# **The Northwood Action Group Inc**

### **Subject: Objection to Redevelopment of Greenwich Hospital (Amended Concept Proposal) SSD 8699 and Response to Submissions**

VIEW FROM NORTHWOOD HOUSE
50MM VIEW FROM UPPER FLOOR VERANDAH
FLOOR HEIGHT ESTIMATE RL 48.0 FROM SIX MAPS LEVELS

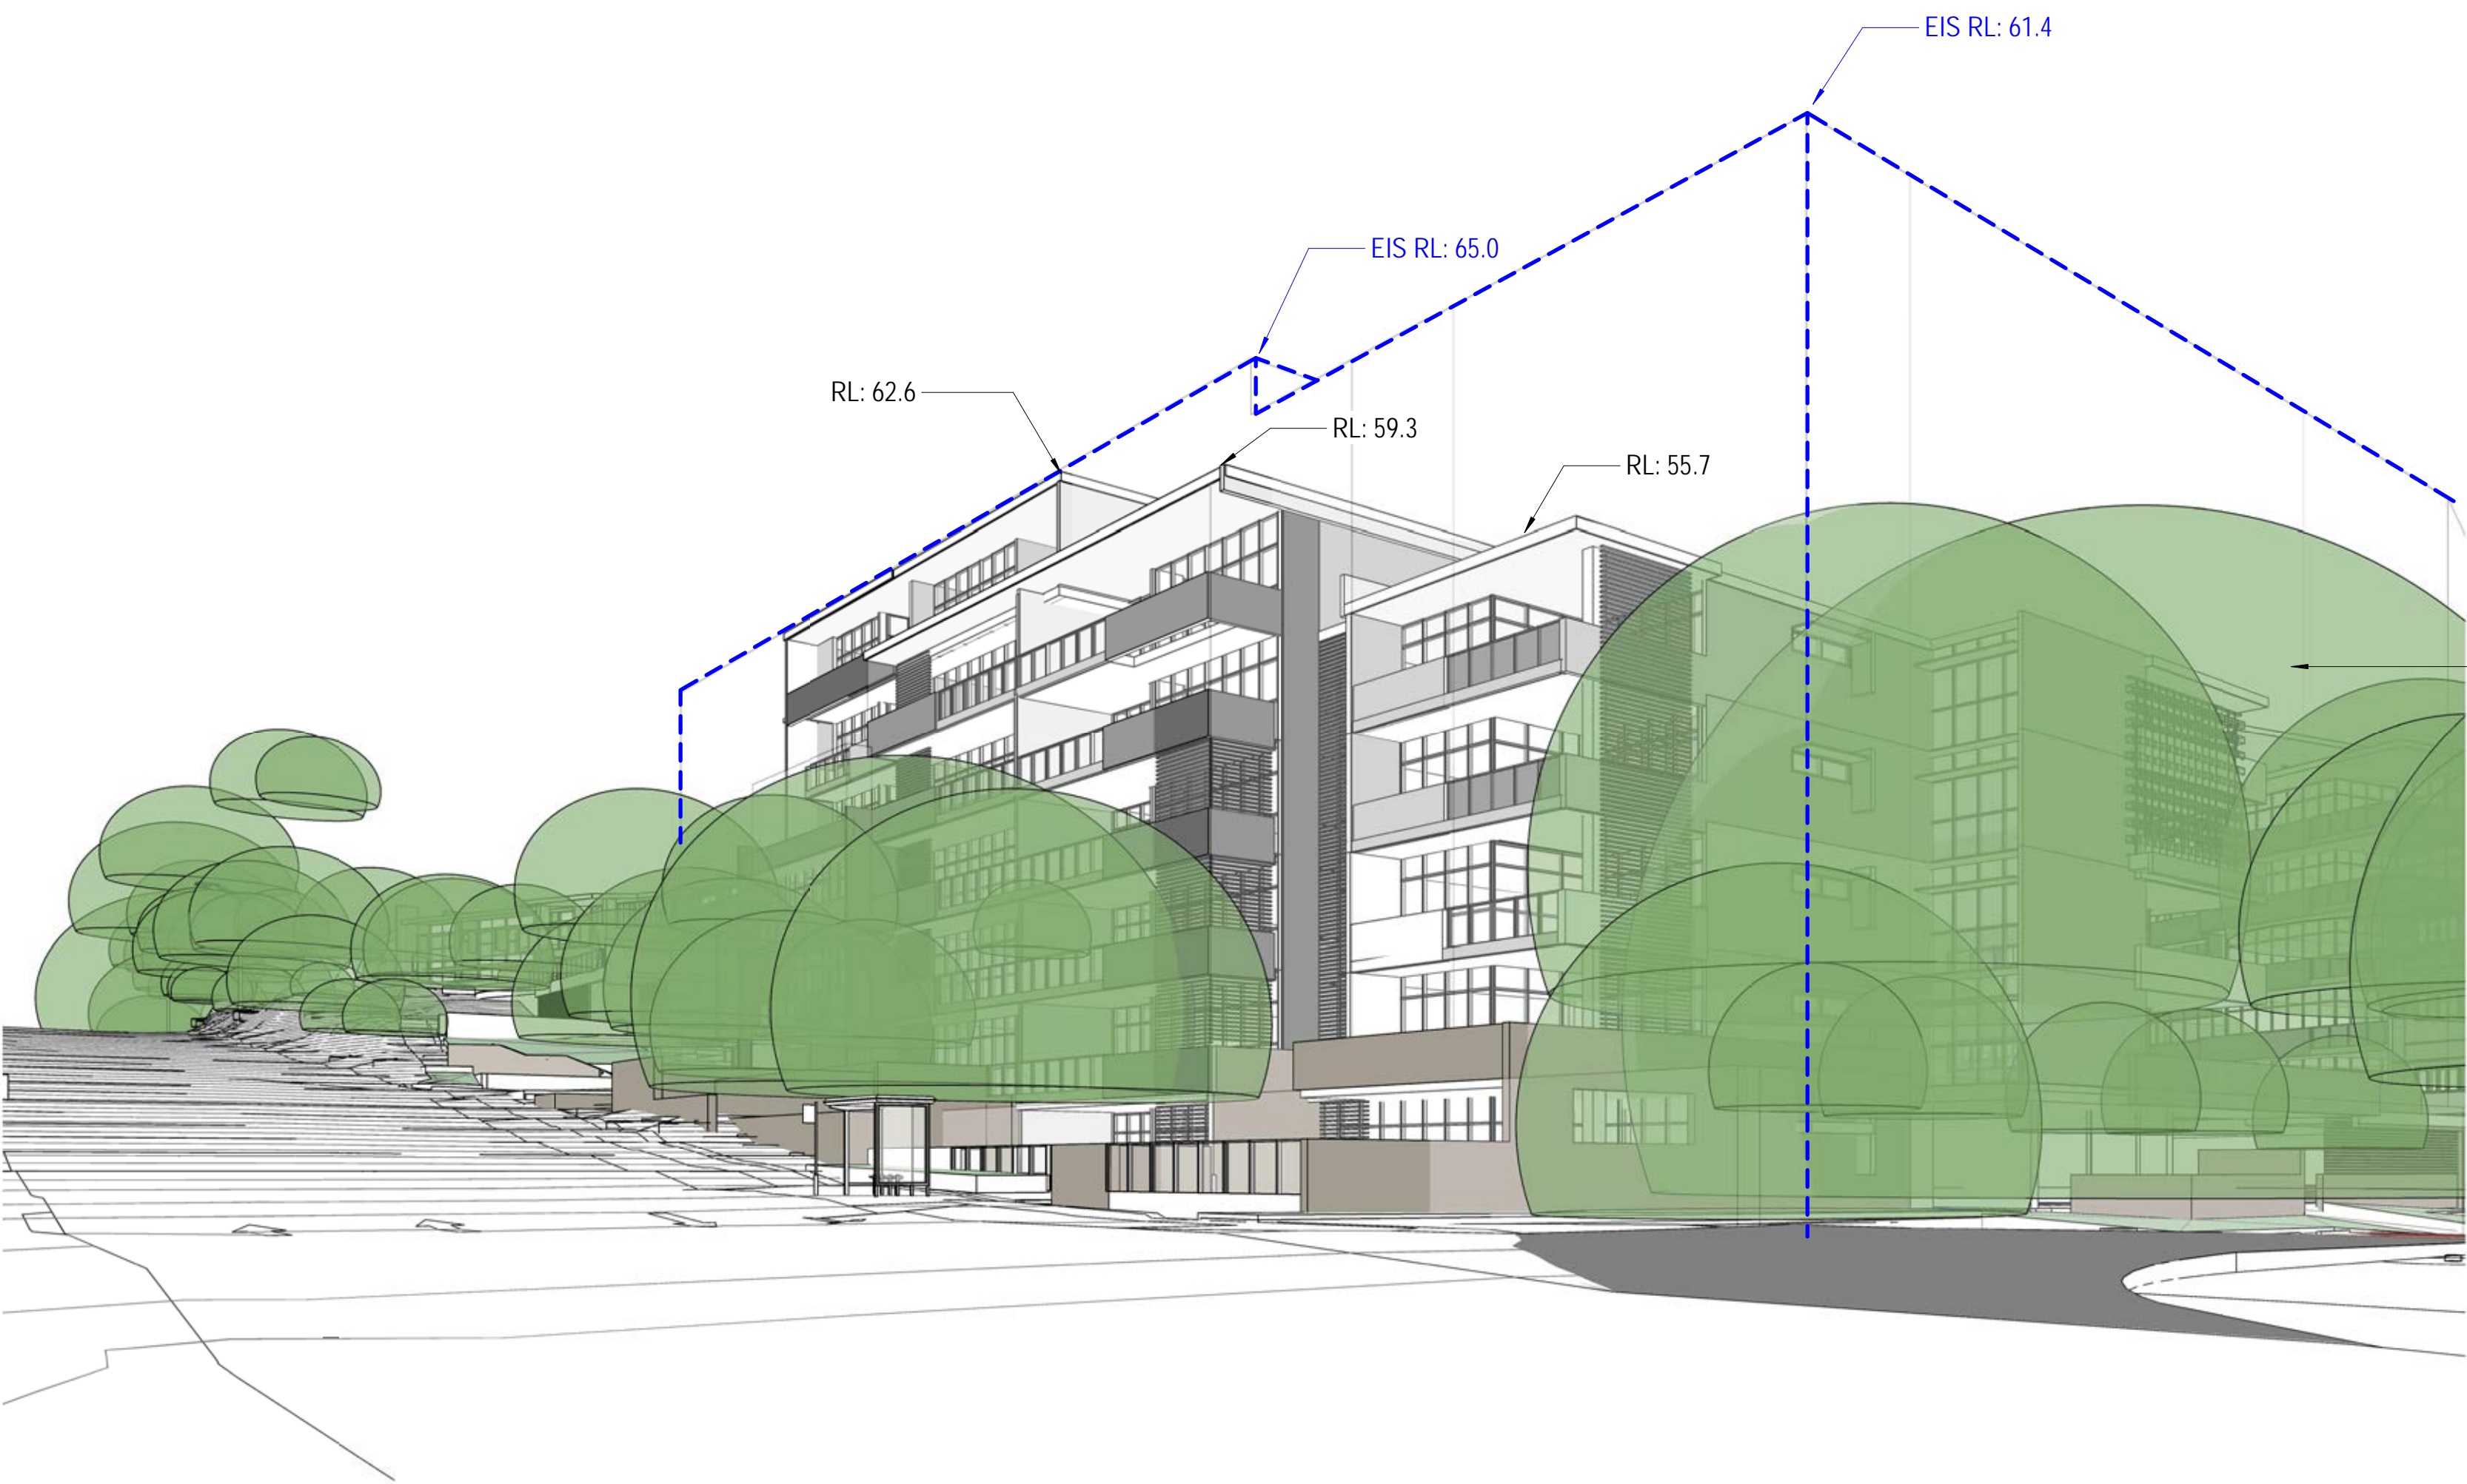
Regarding the Northwood House view, it appears incorrect – it shows almost no perspective at all, but looks rather like an elevation drawing fitted into the landscape. If it was viewed from RL48 as stated, all the parts of the built form which are above this level would appear to be higher with the correct perspective. Thus as RL 63 the Seniors Living blocks would show up as being higher than the viewer position, instead of being on the same level as the viewer, which they do in the illustration reproduced.

DRAWING TITLE:
SHADOW DIAGRAMS - WINTER SOLSTICE
12pm
DATE:
AUGUST 2019
DRAWN:
EC
PROJ:
1213
PROJ ARCH:
BF
DRAWING:
IN.91
SCALE:
1:1000 @ A1
REVISION:
P2

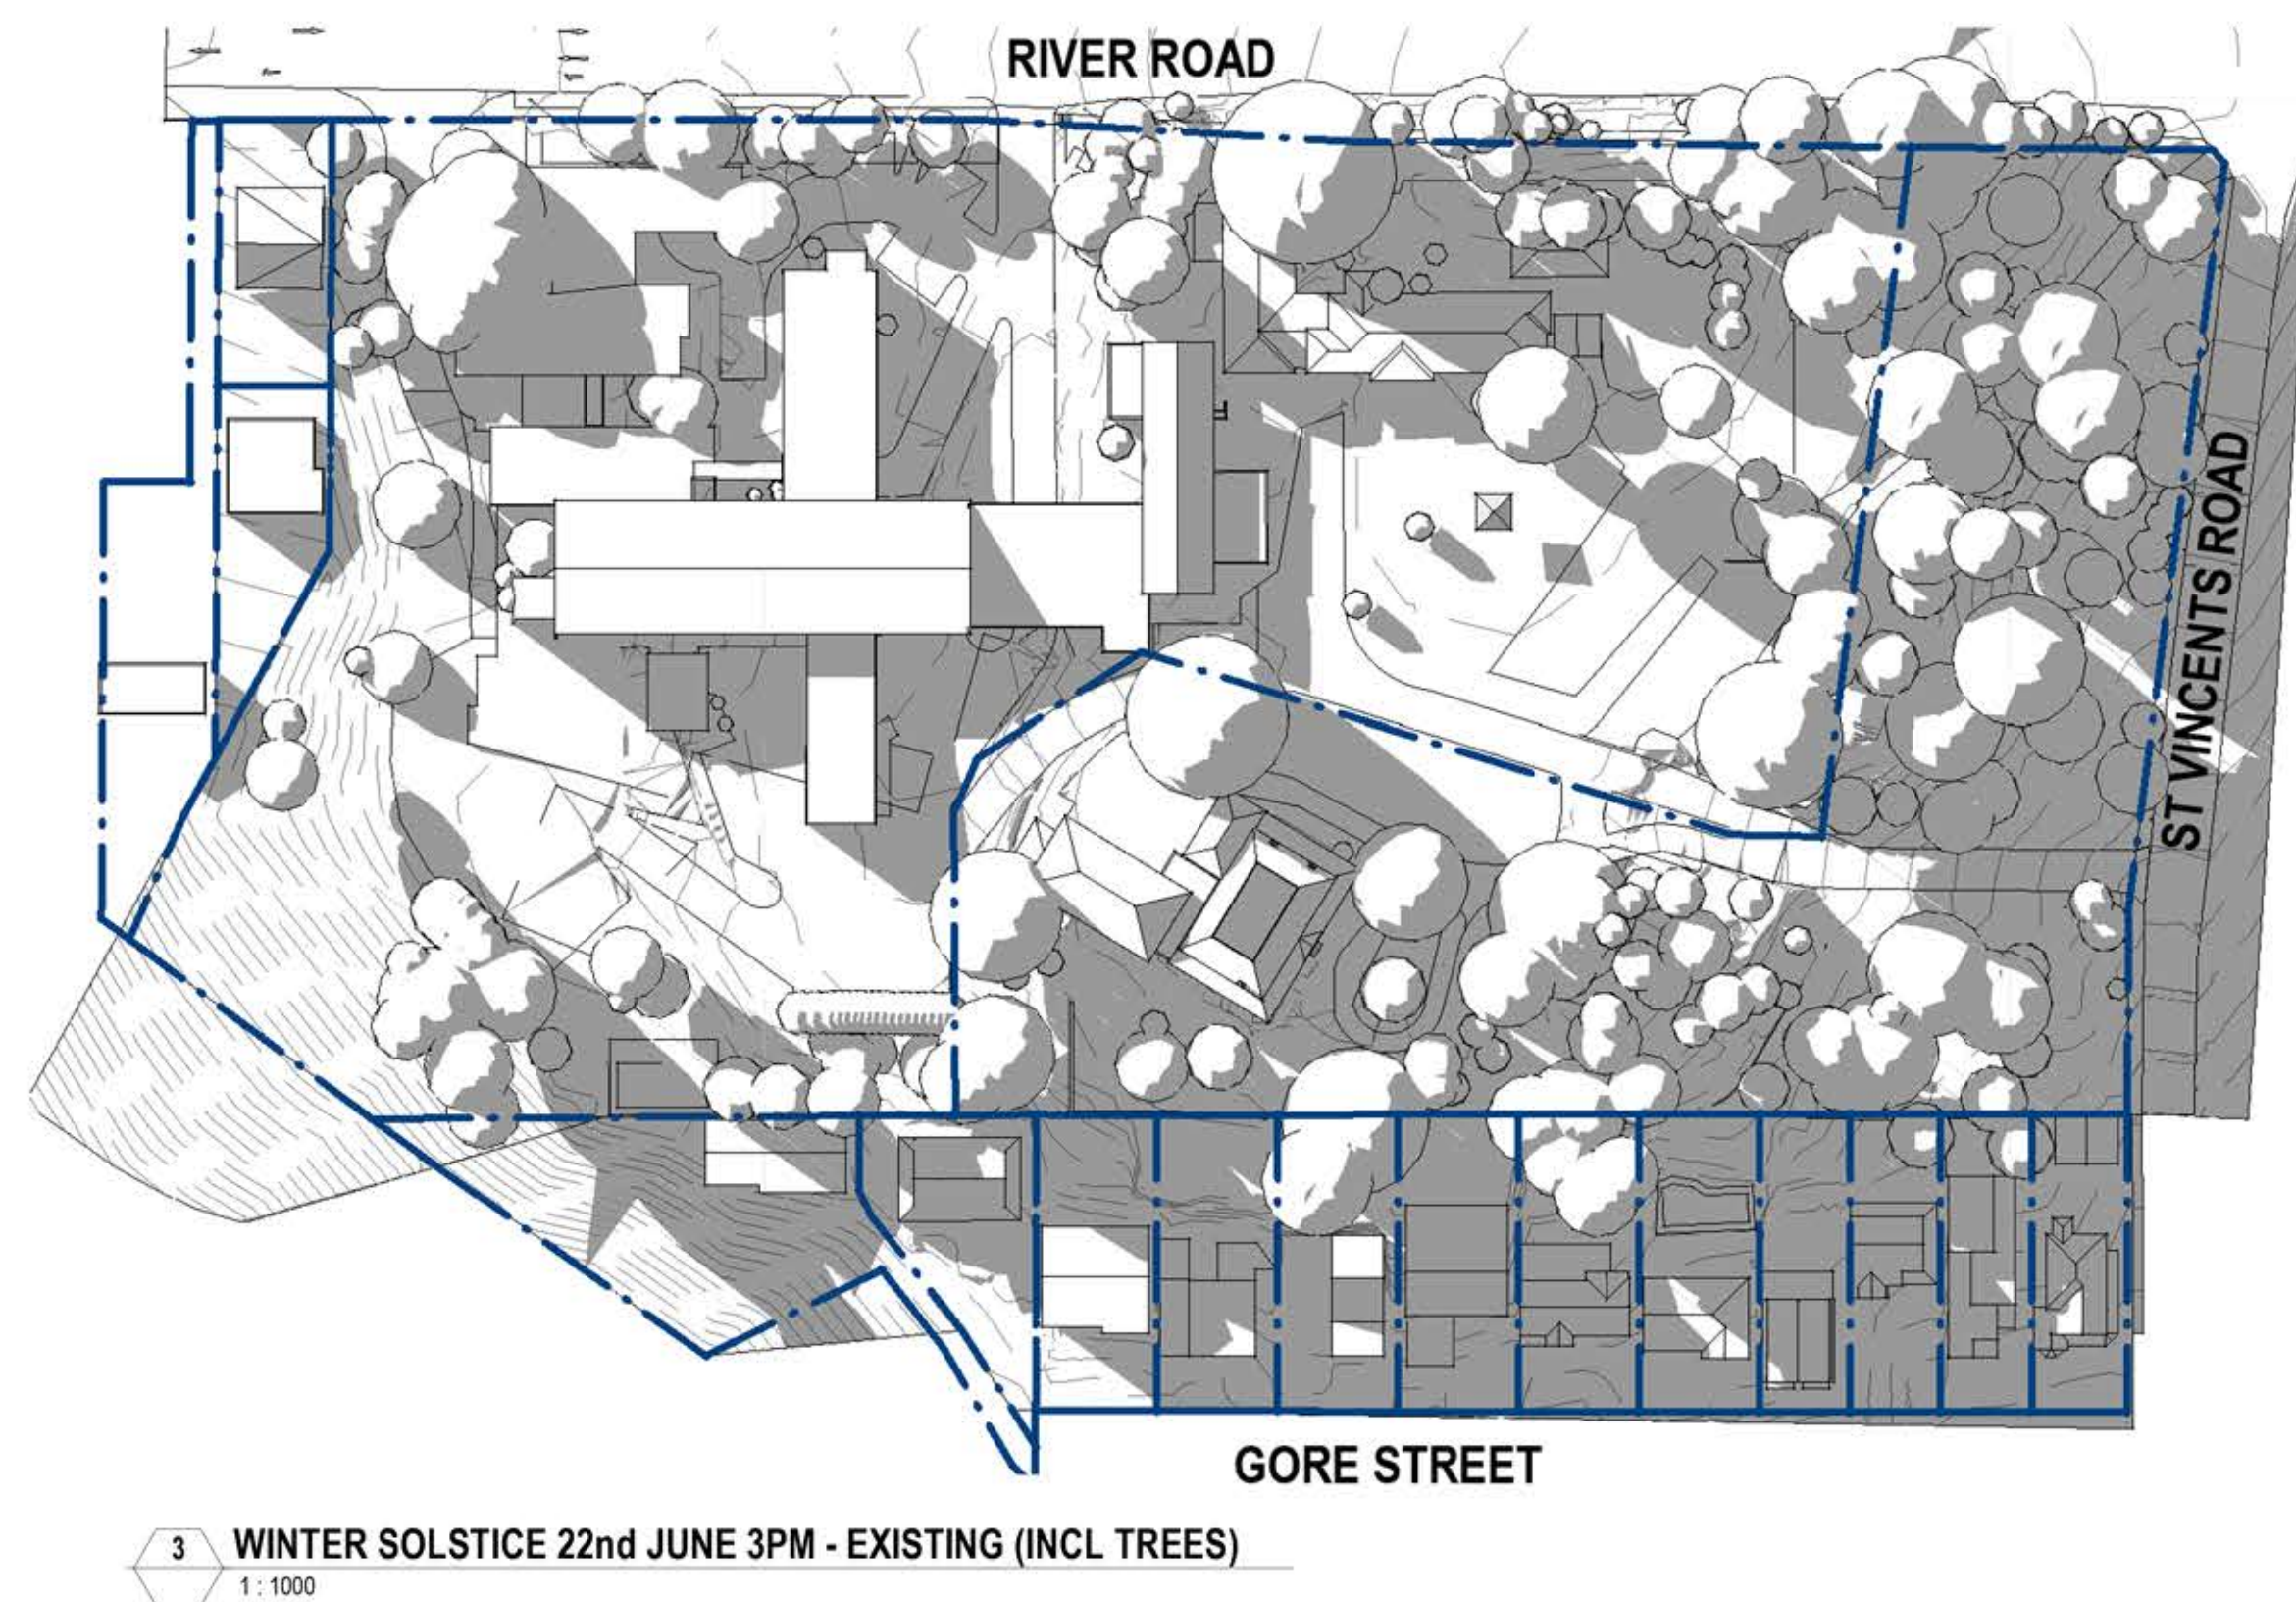
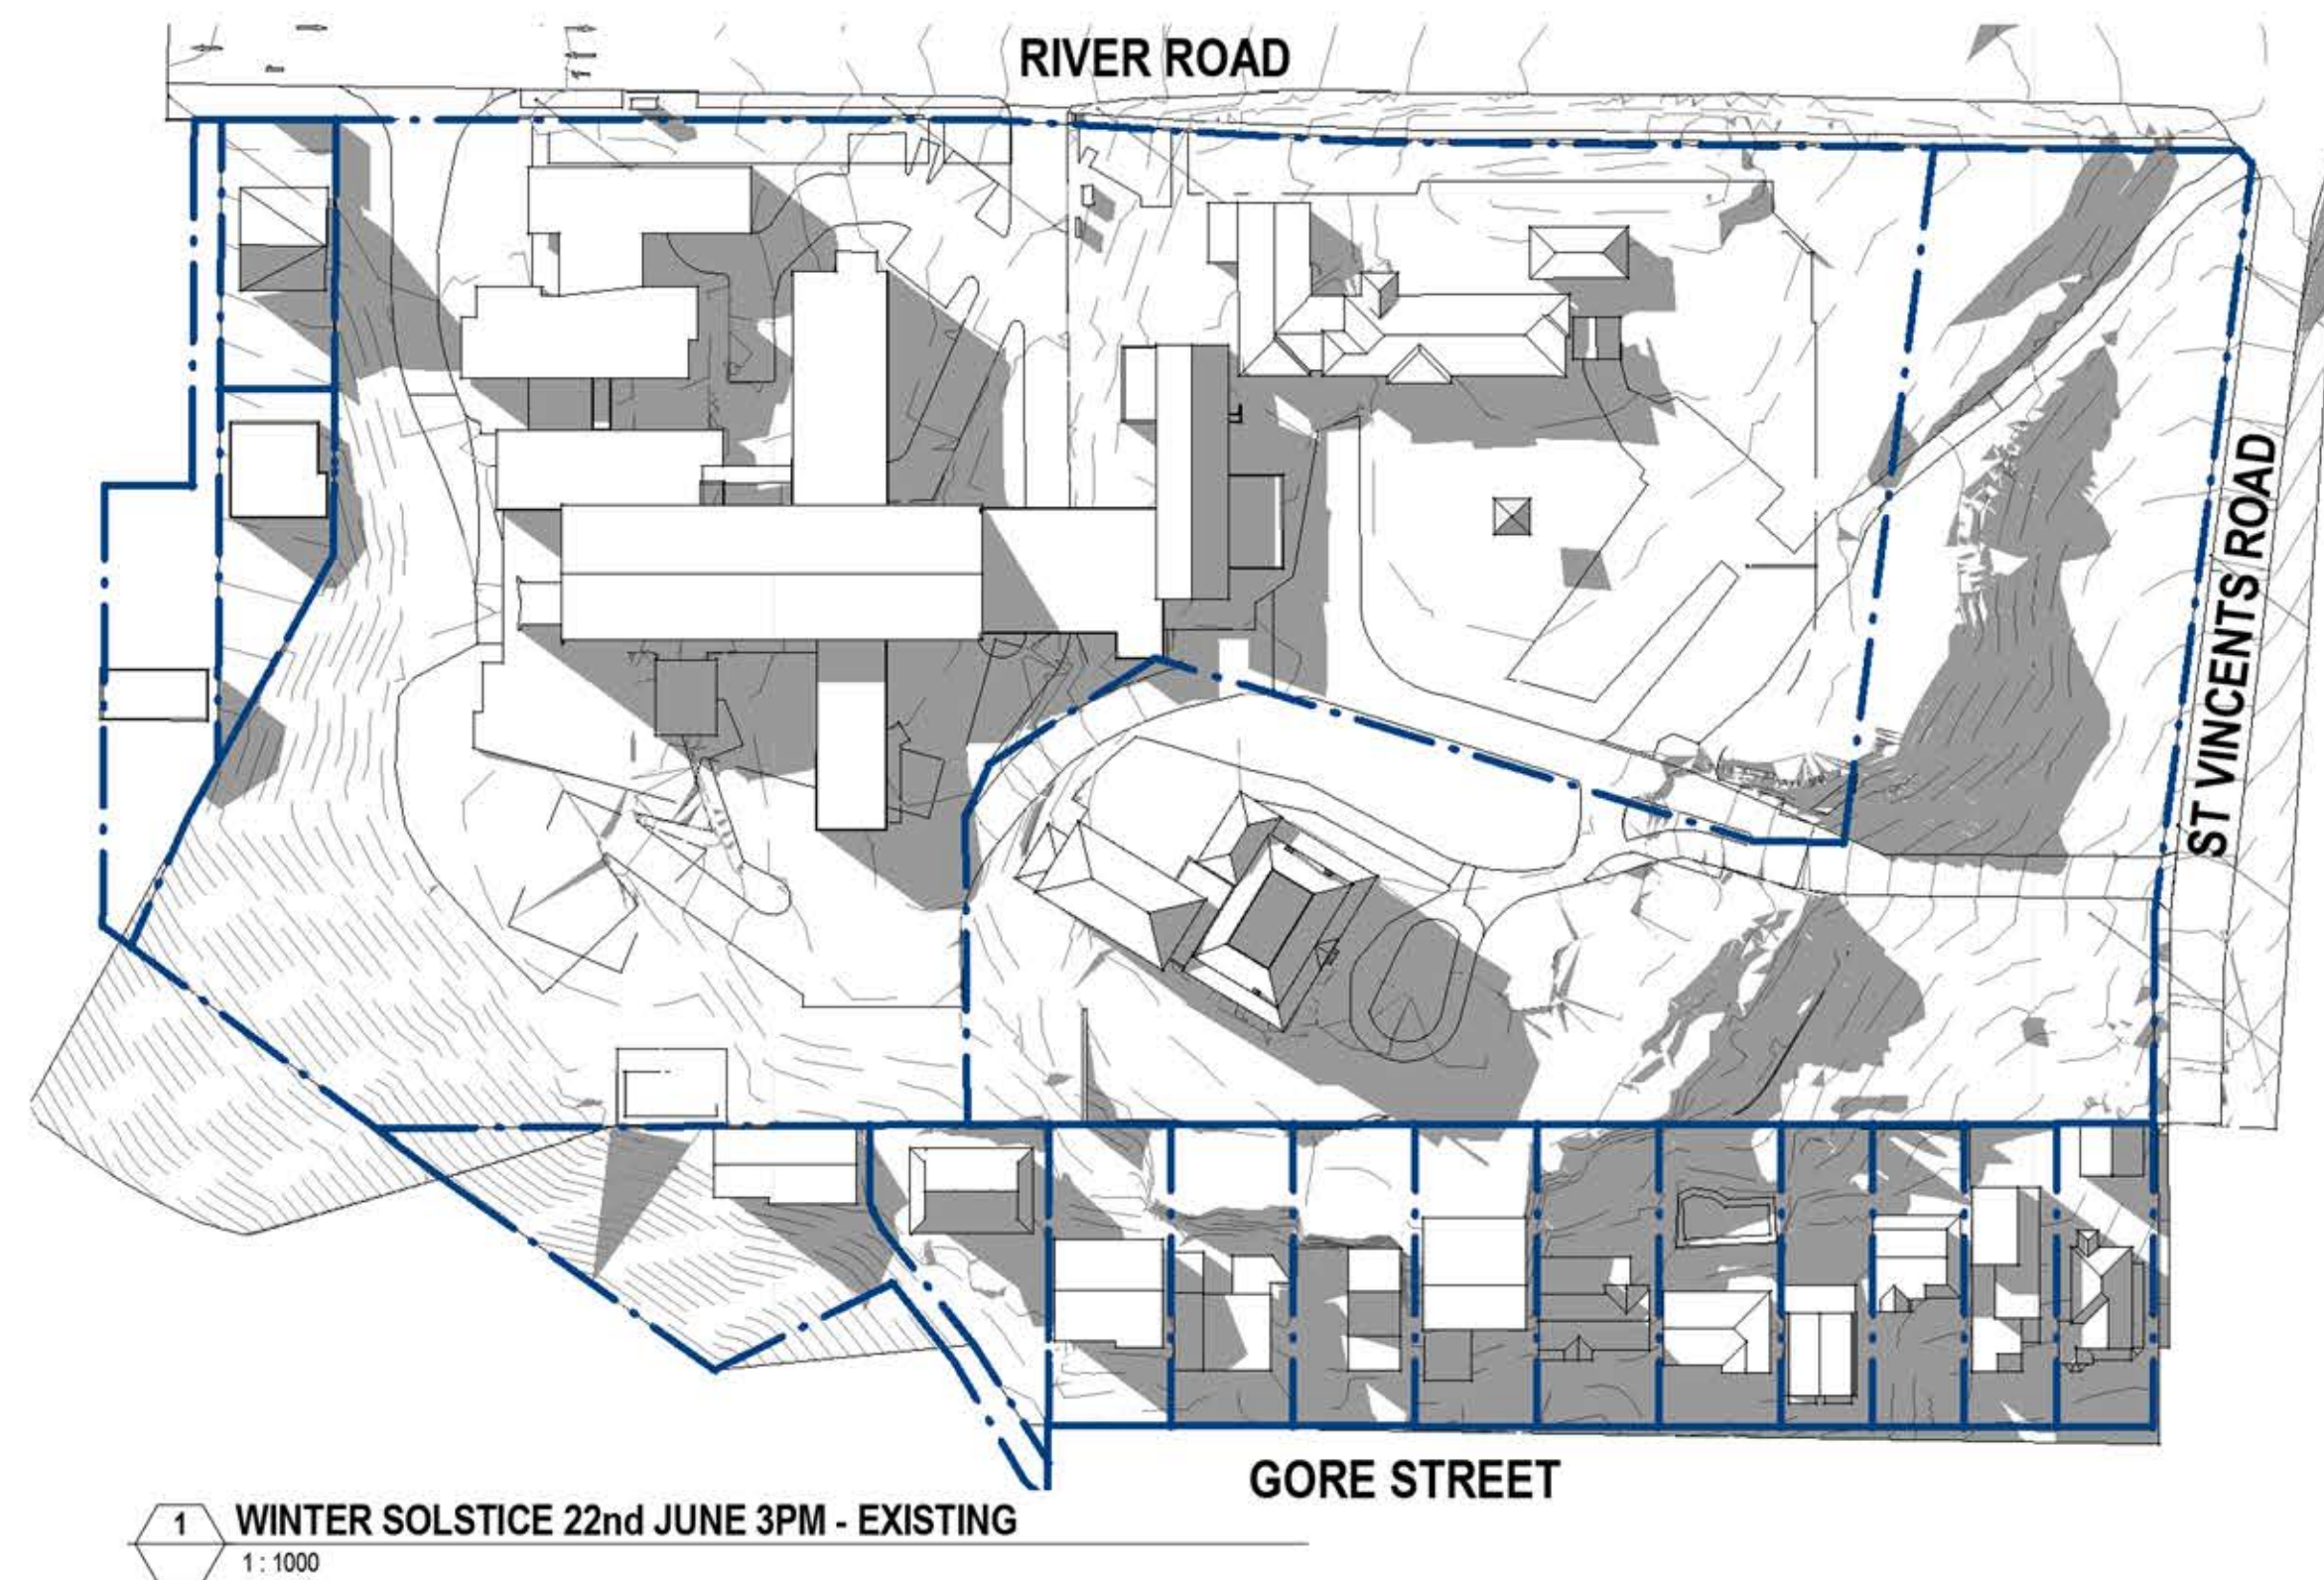
- incorrect shadow diagrams
- incorrect information on landscape
- no reliable tree survey in the bushland area
- bushfire report and information on which RFS has based its comments will be wrong
- incorrect hydraulic flow calculations
- trees (which are offered as future planting to "screen" the Seniors Living from Northwood) will not grow on cliffs, and if growing at the much lower level which is the reality on this south-western portion, will take a very long time to even reach the top of the cliff, let alone screen .
